Westmead Catholic Community Education Campus (SSD-10383)
Response to Submissions

ATTACHMENT 1 – KEY ISSUES

Ground Level: Solar Access (Winter Solstice, 21st June)

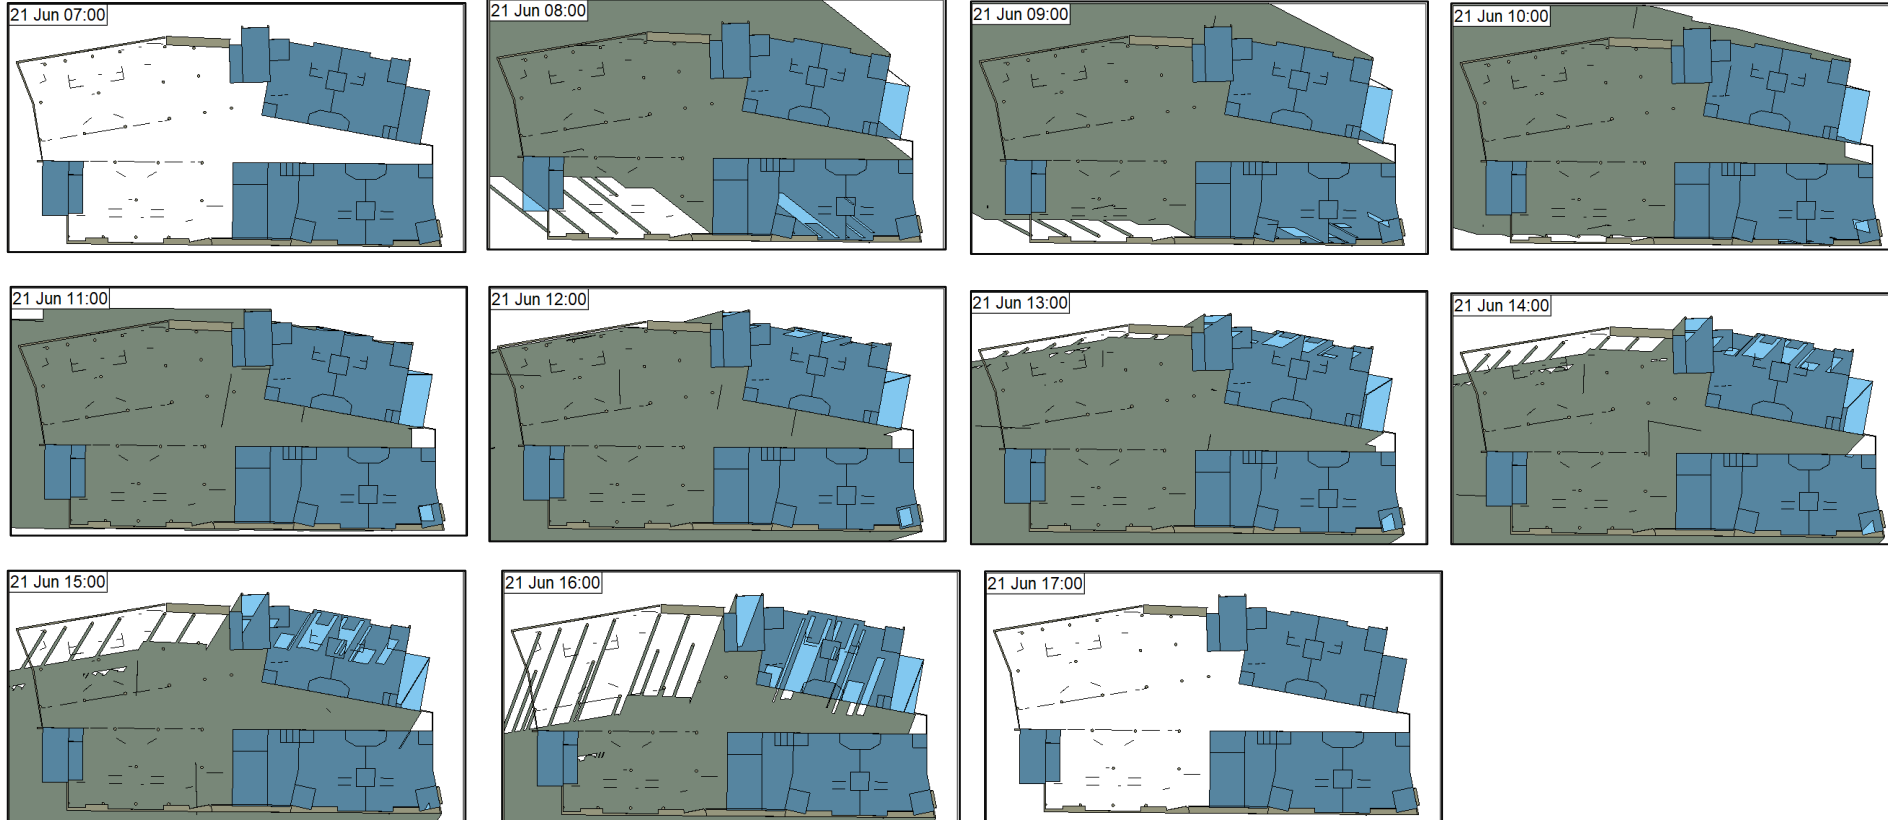
- no details have been provided regarding the solar access / daylight access provisions to the upper level open spaces. Given the nature and design of the open spaces, it is likely that these areas would not receive sufficient sunlight (in excess of three hours) during the winter solstice.

FLOOR PLAN - GROUND FLOOR

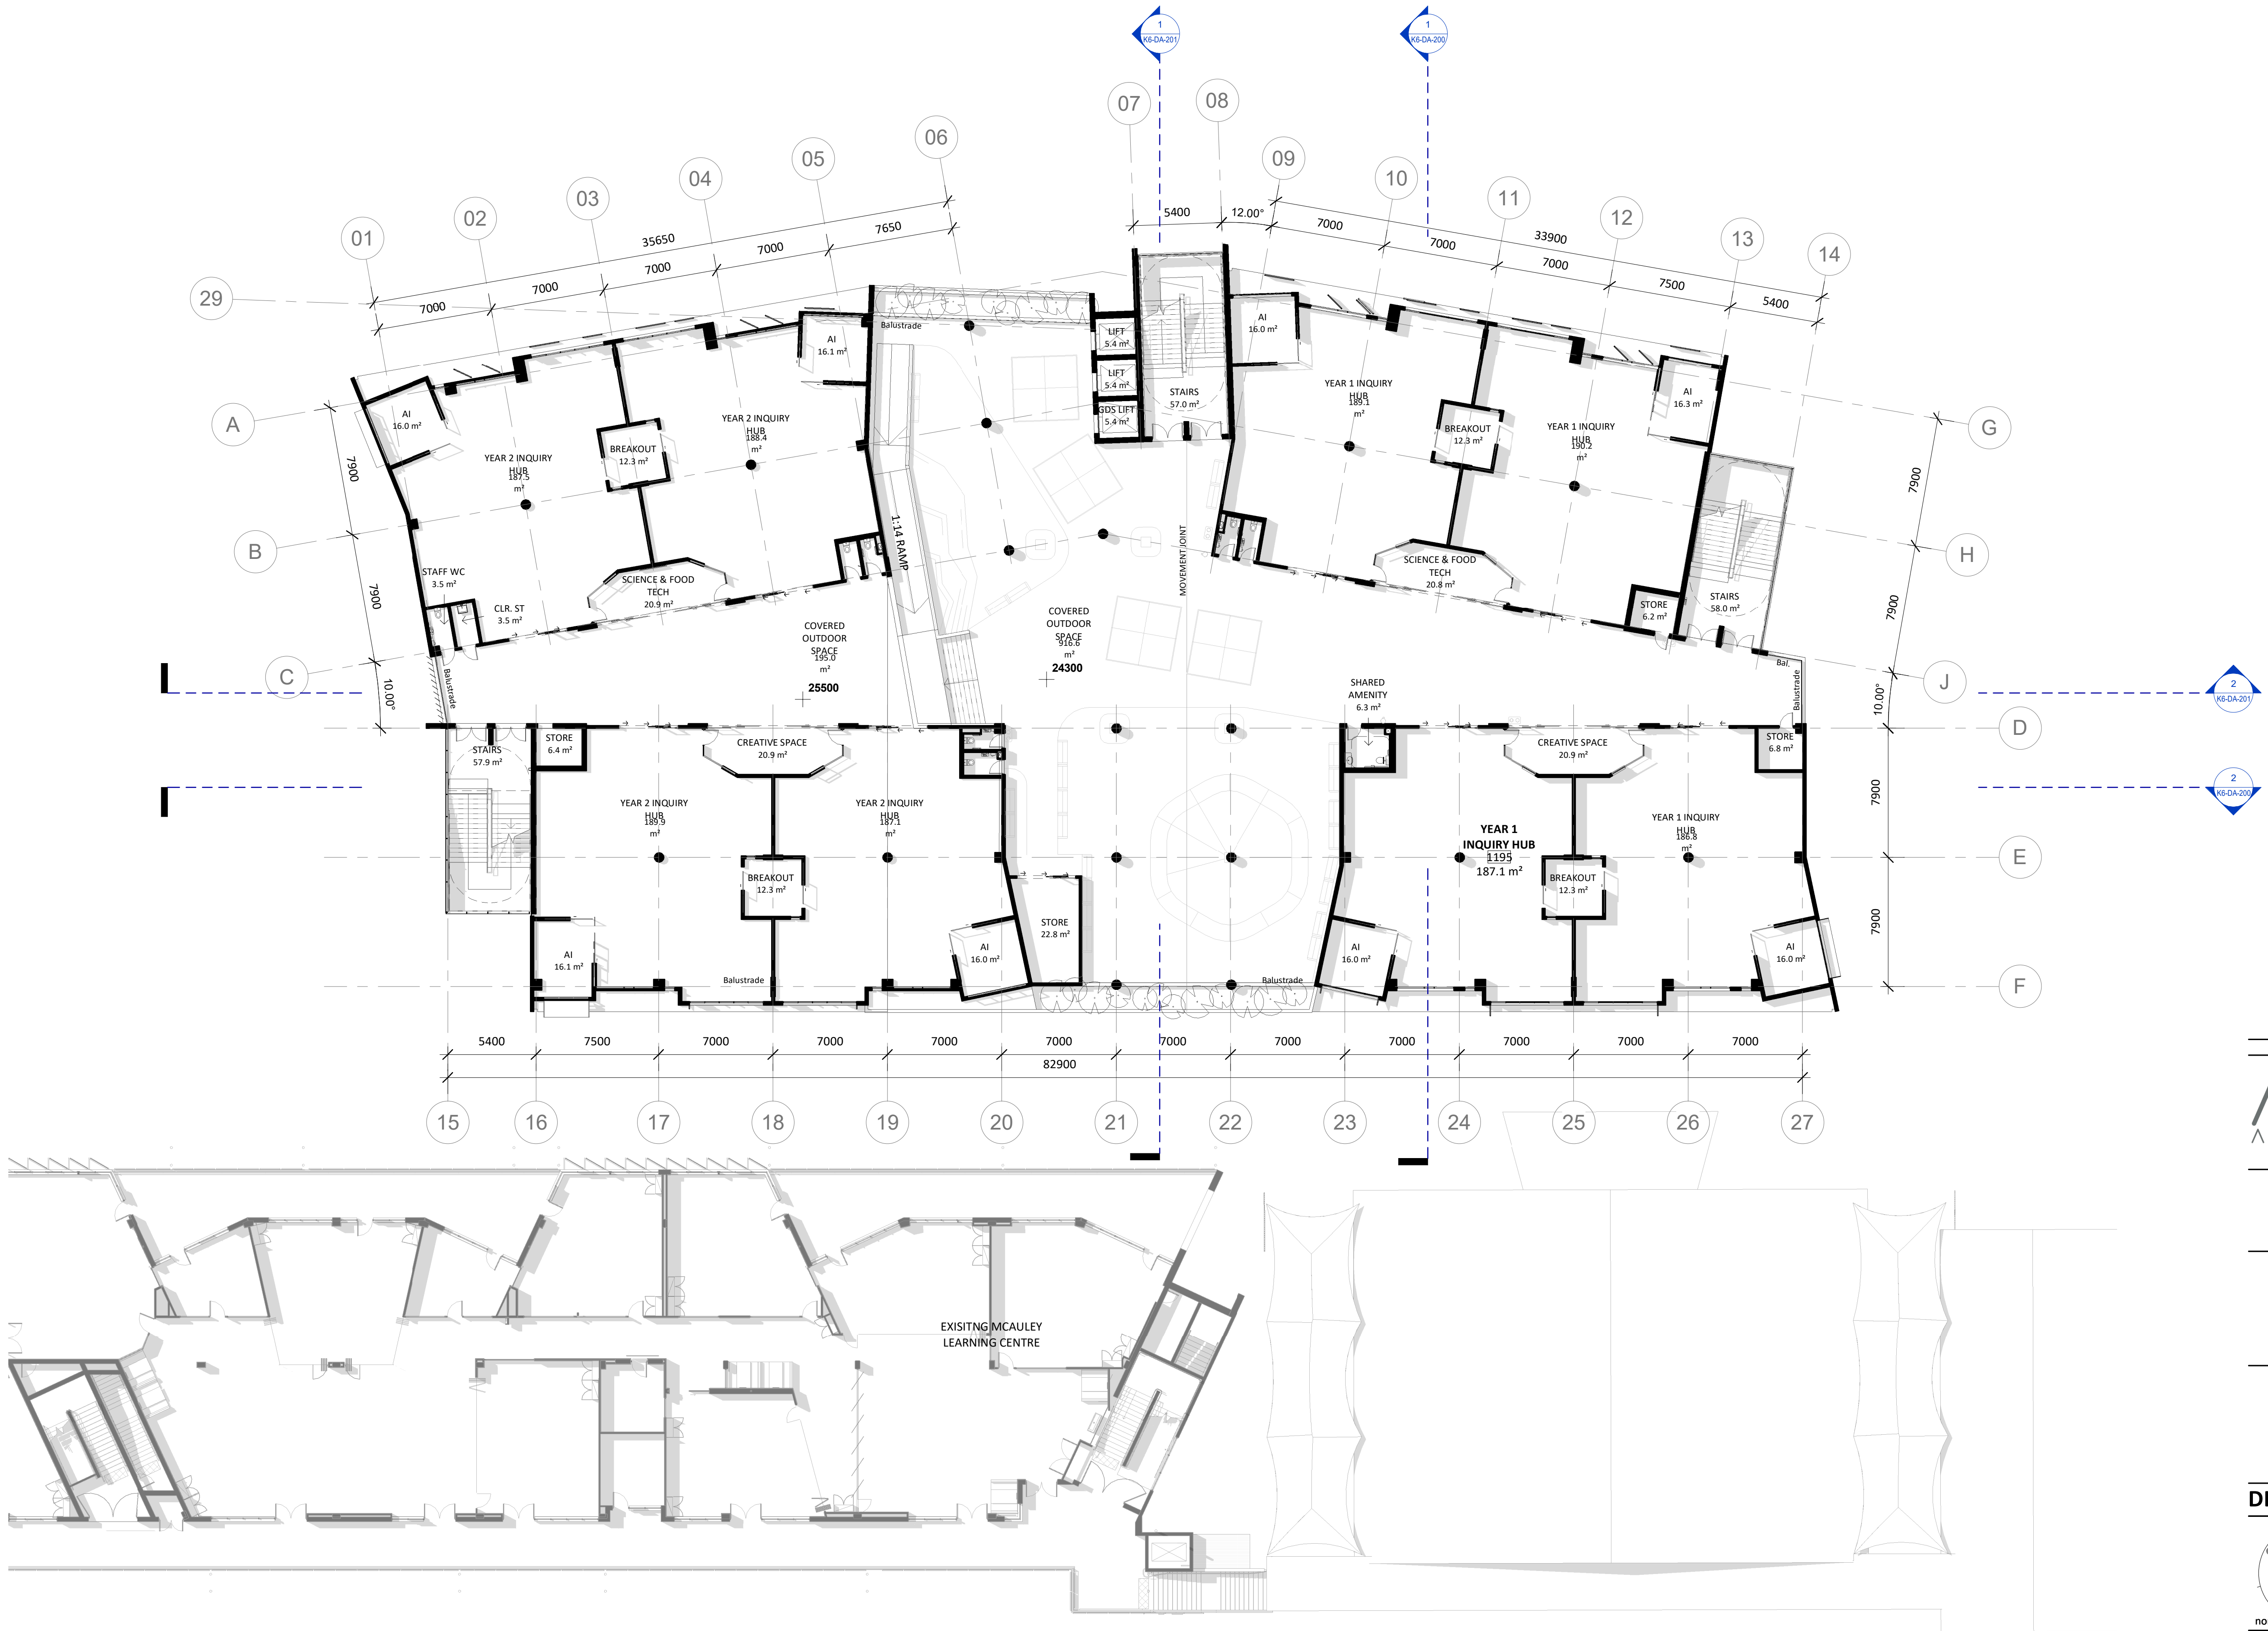
- The Submitted architectural plans do not clearly differentiate which parts of the ground floor of the primary school is covered and are within the building envelope. Therefore, revised architectural plans are to be submitted to clarify this.
- The revised plans must include the outline of the roof over each floor to identify the covered open space area on each level.

1 BALUSTRADE - TYP.
1 : 20

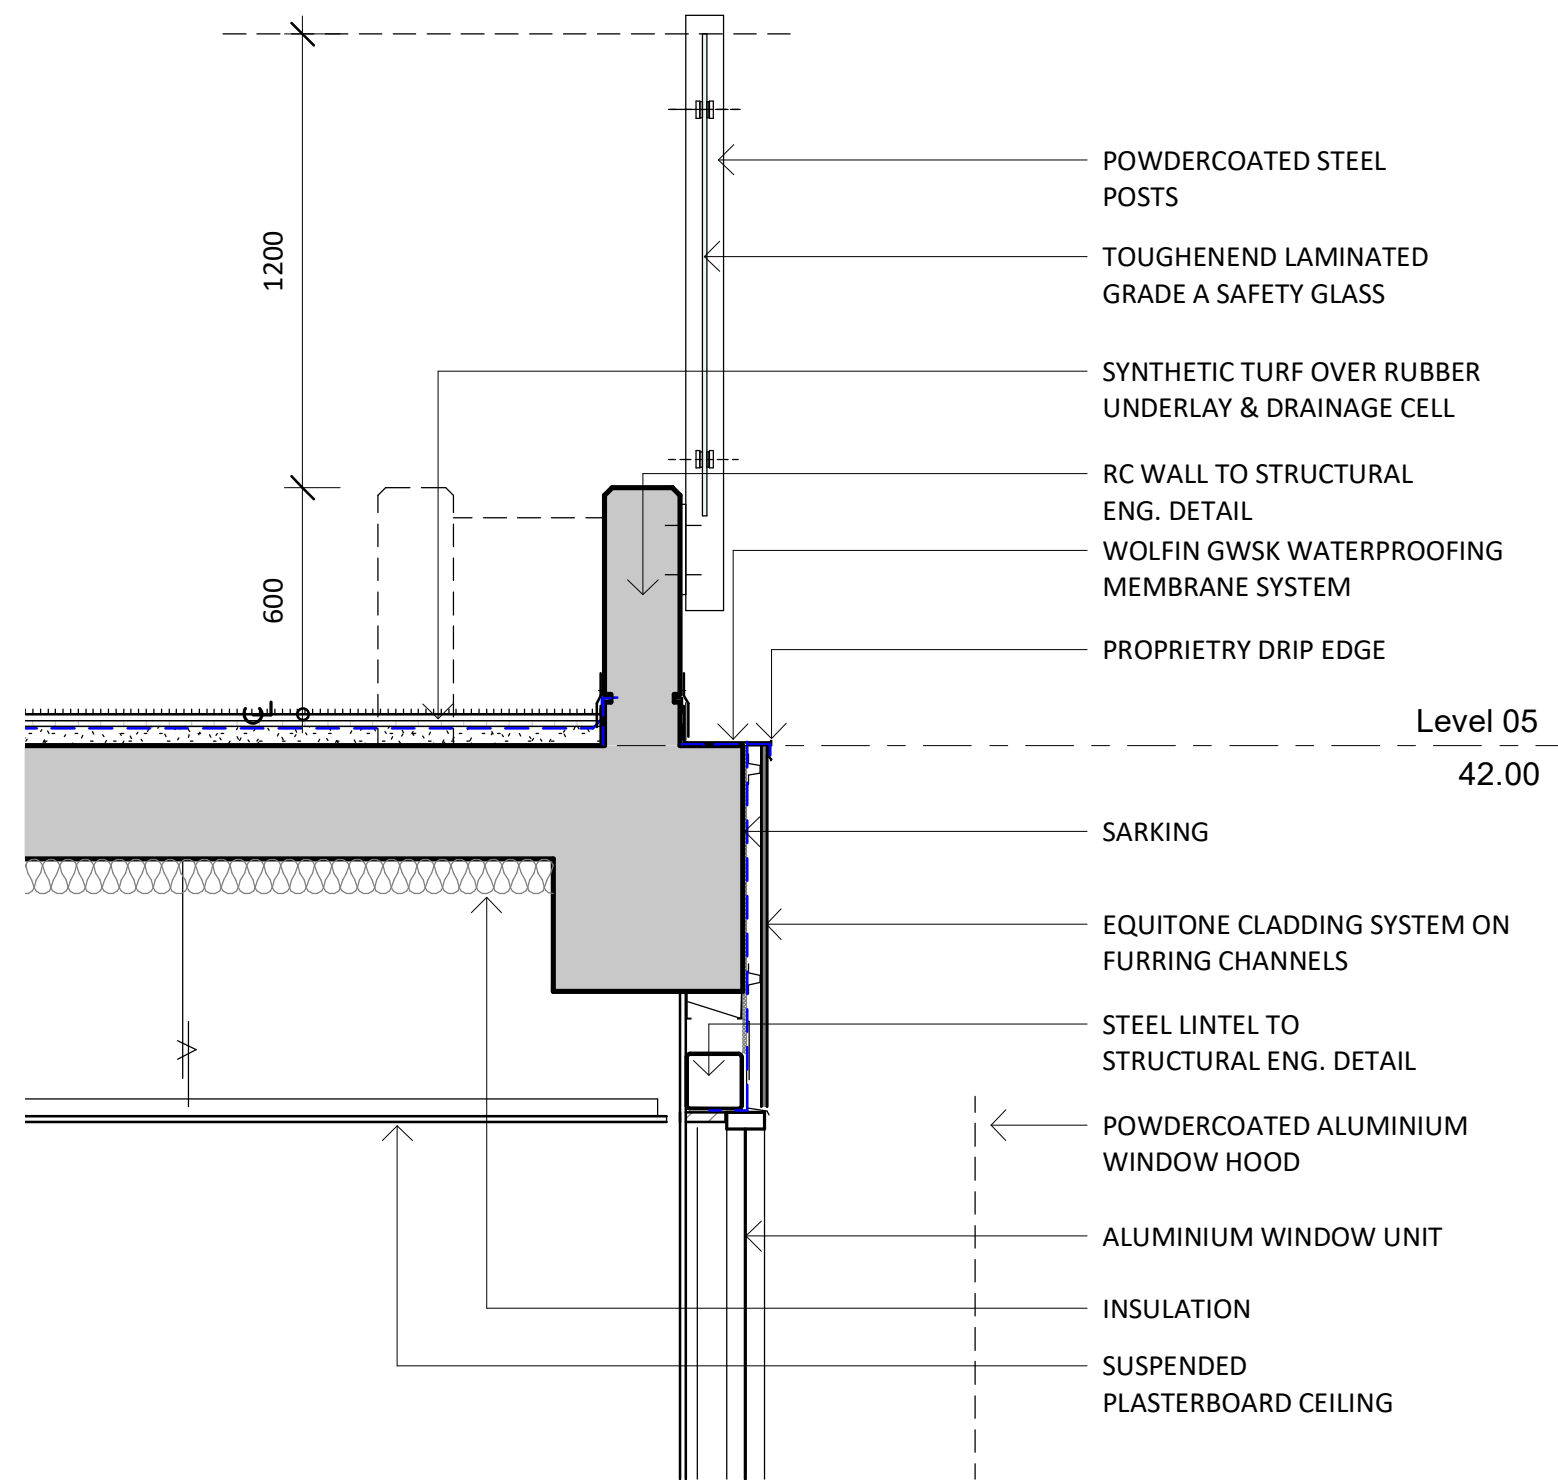
- no details have been provided regarding specific safety features (such as balustrades / nets) that are proposed to ensure safety of the students using the upper level open spaces of the building.
